From: Tony Phebey [REDACTED]
Sent: 13 May 2020 08:35
To: Zac Denton <Zac.Denton@arun.gov.uk>
Subject: Re: EP/25/20/CLP - Confirmation of materials

This email is regarding the above application at The Millstone, Sea Lane Close, East Preston.

1437/P02

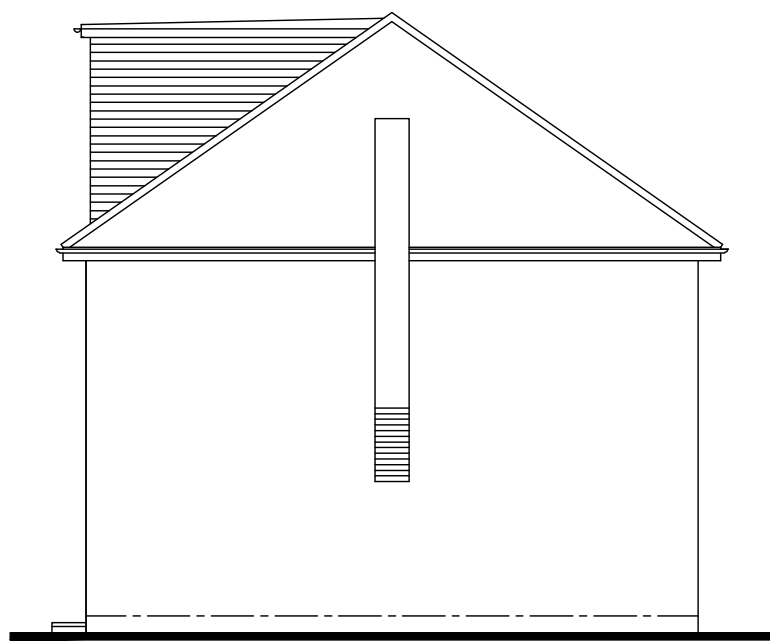
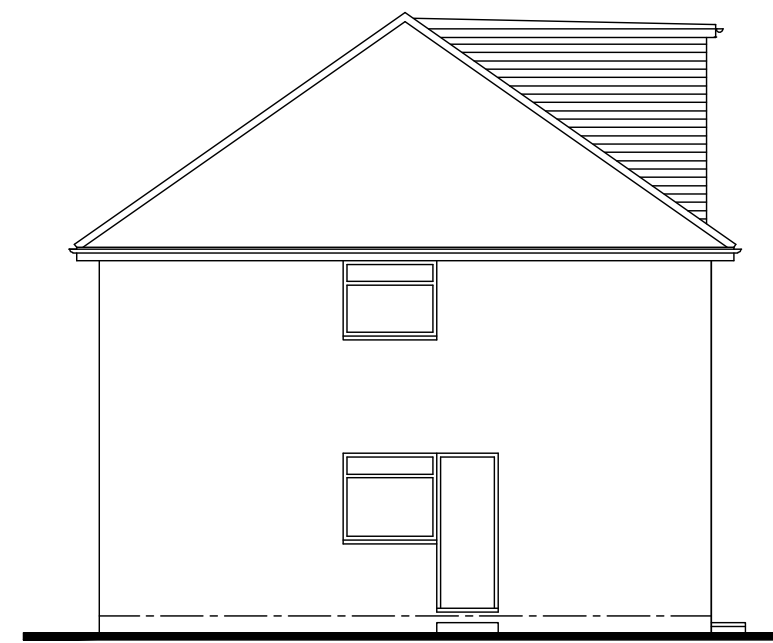
Sorry to chase, but are you able to clarify the colour of the tiles used?

The 'Walls' has been detailed as 'Tile Hanging Colour T.B.C', are you able to confirm the material that will be used?

To match main roof tiles.
